Town & Country Planning Act 1990 (as amended) s211 Notice
Application for Prior Notification of Work to Tree(s) in a Conservation Area

Development Trees in conservation area.
Location Archways 19 Wychwood Close Craigweil

LOCATION OF TREE AT 19 WYCHWOOD CLOSE

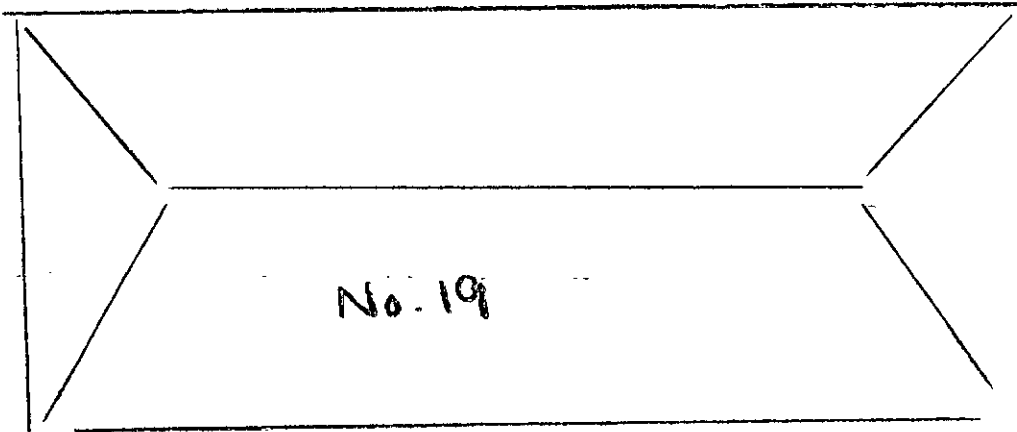
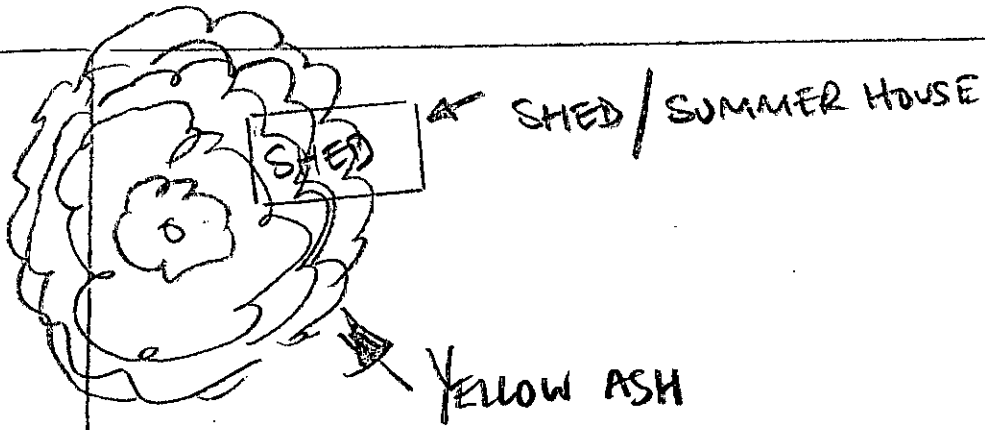
Please confirm if the tree was in situ in 1958.

Please confirm if Crown reduction or Crown lift, and branches to be removed in metres. Or, if a crown thin and confirm % to be removed.
